Re: Addison Galaxy FBO Civil Plan Review

Development: Galaxy FBO  
Town Project #: 19-09D  
Plan Review: 1<sup>st</sup> Civil Submittal

Summary of Engineering Review Comments

SHEET NUMBER  
**C14.03**

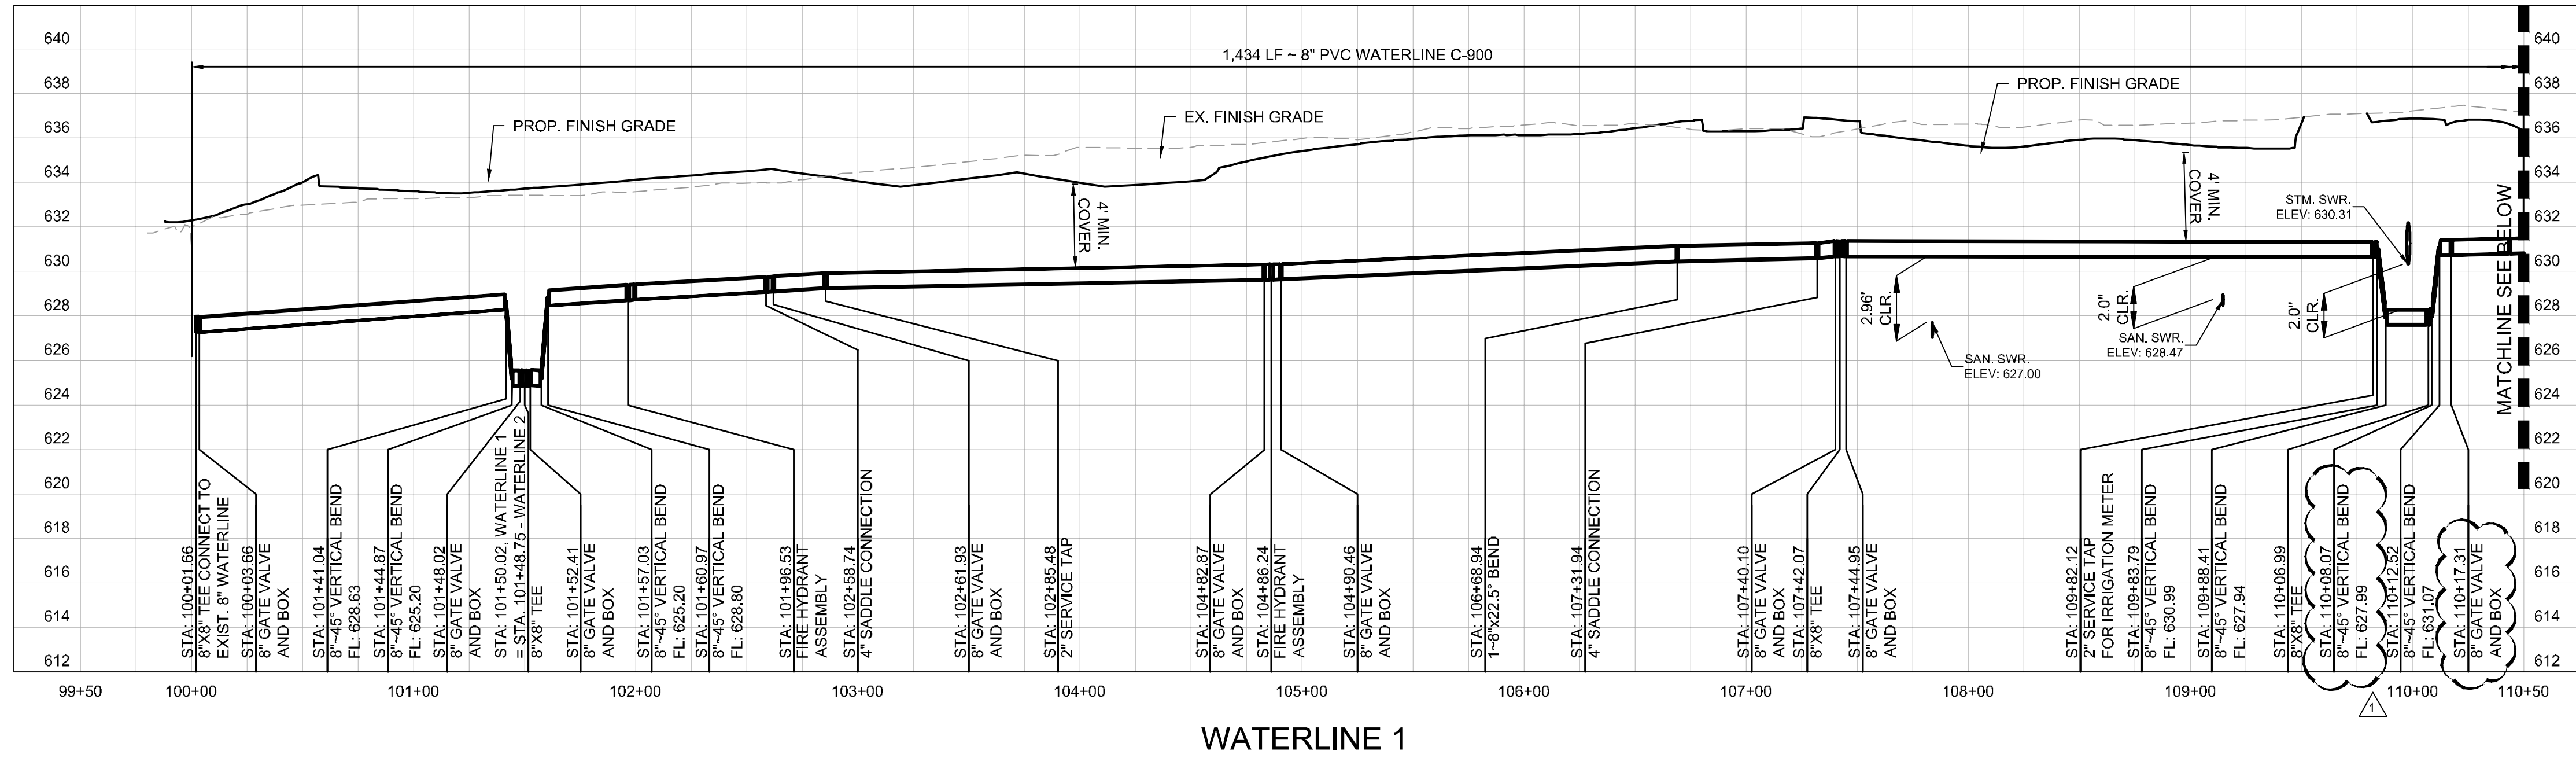
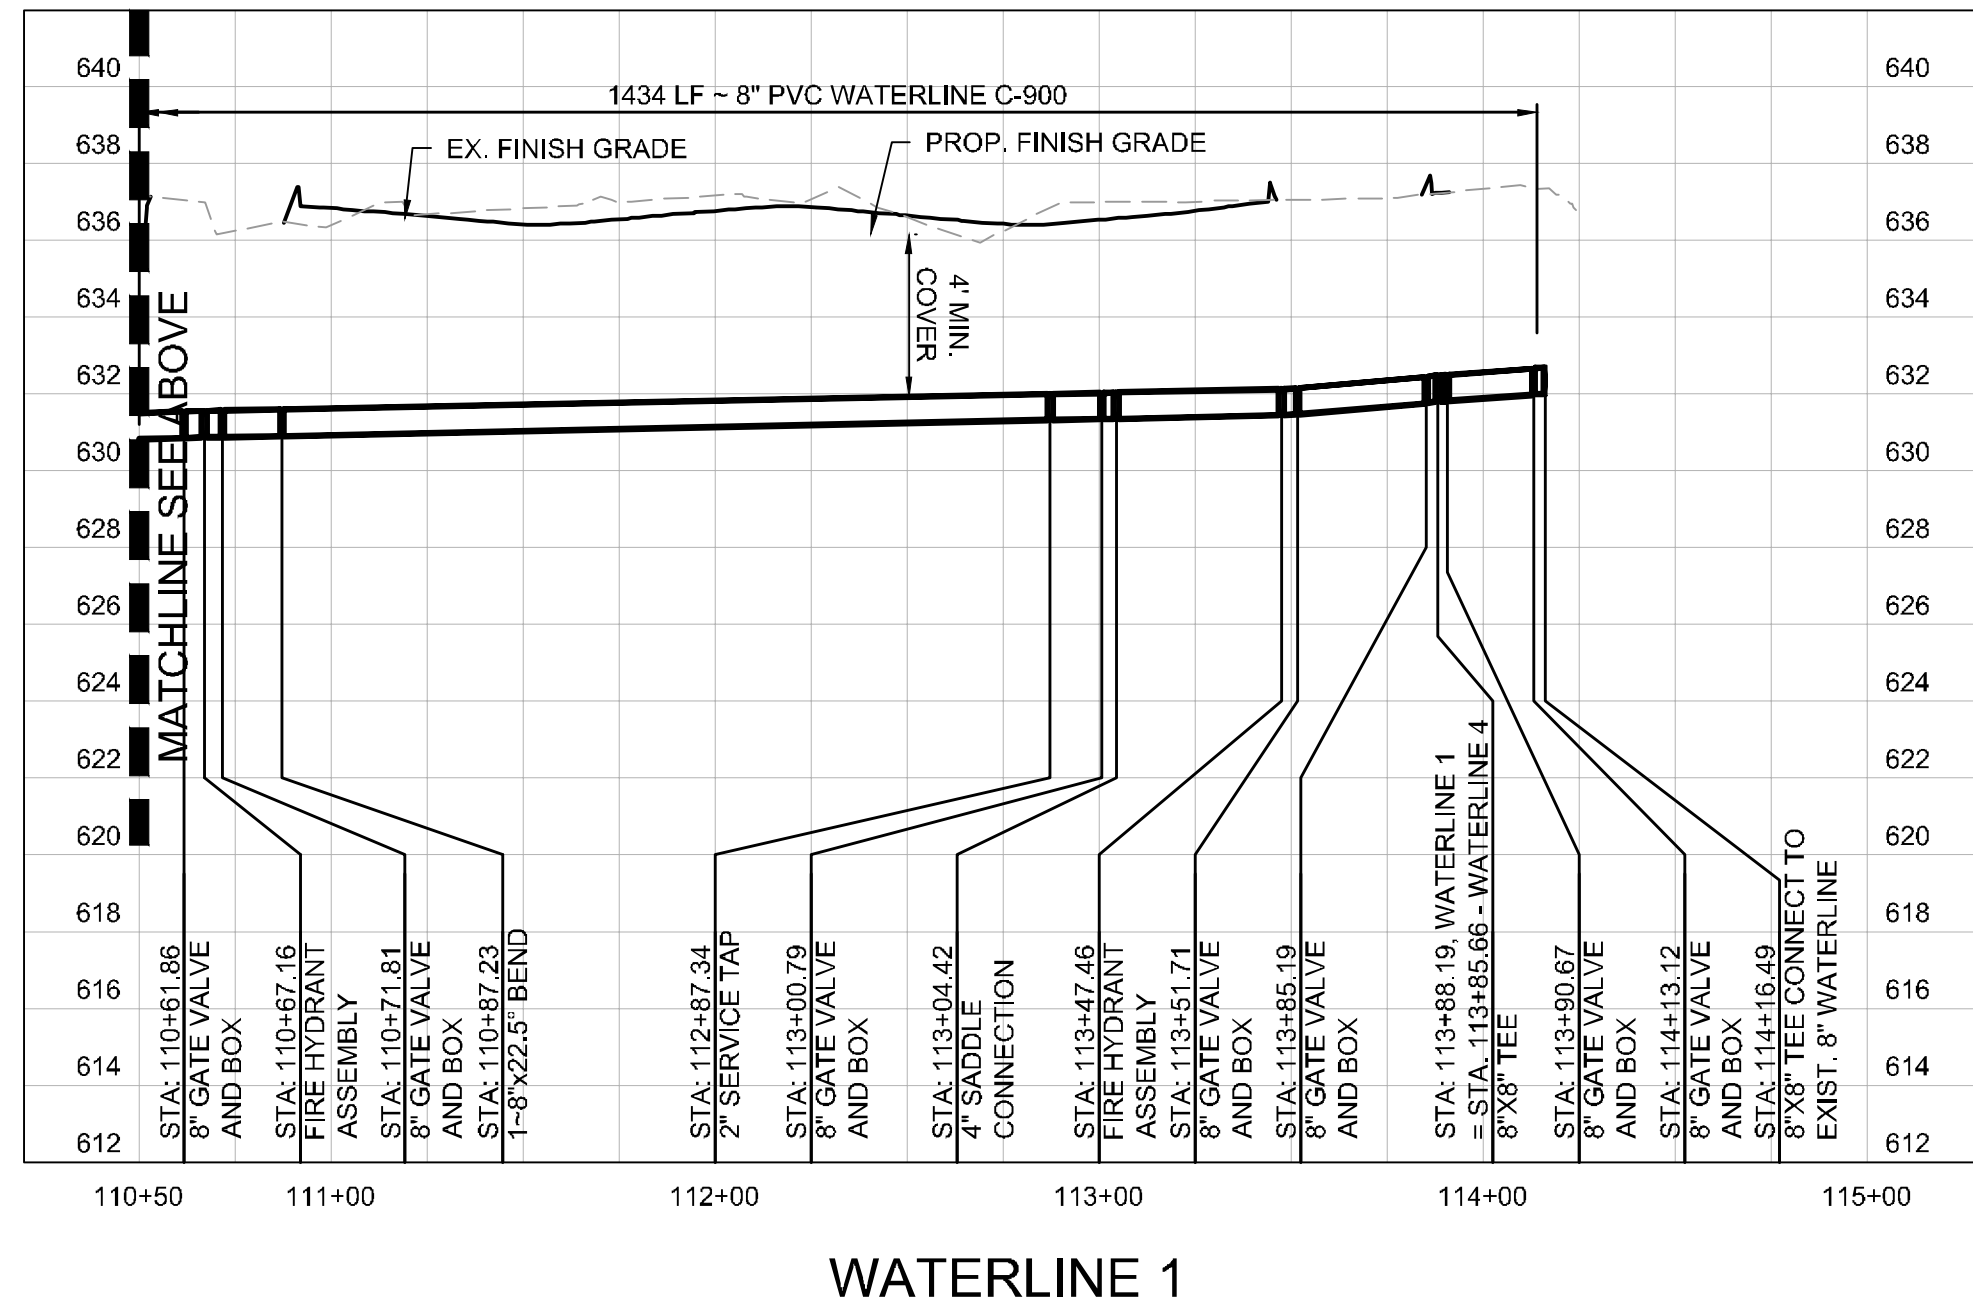
C14.03	Show all crossings, including service crossings, in the profiles.		
C14.03	Show valves in profiles.		
C14.05	Not using RCCP water main - don't include RCCP embedment detail - use PVC detail SD-W01.		
C15.00	Dimension the separation from the water & gas (min. 4')		
C15.00	Include profile for Addison Rd crossing.		
PVMT MARKING	Airside markings need to reflect access road changes. Coordinate with the airport & Garver.		
PVMT MARKING	Stripe applicable areas in front of/near FHA's on the airside for NO PARKING. Include detail (similar to sketch on C16.04) for striping & bollards/guard posts.		
C16.04	Extend fire lane stripes all the way to access gate between Hangar I & FBO.		
C16.04	The circle under the canopy on FBO is striped as fire lane. Interior radii aren't labeled anywhere for these curves - are they fire lane compliant? Does the circle need to be firelane?		
C16.05	Does the paved area north of Hangar III and south of George Haddaway need fire lane striping for George Haddaway?
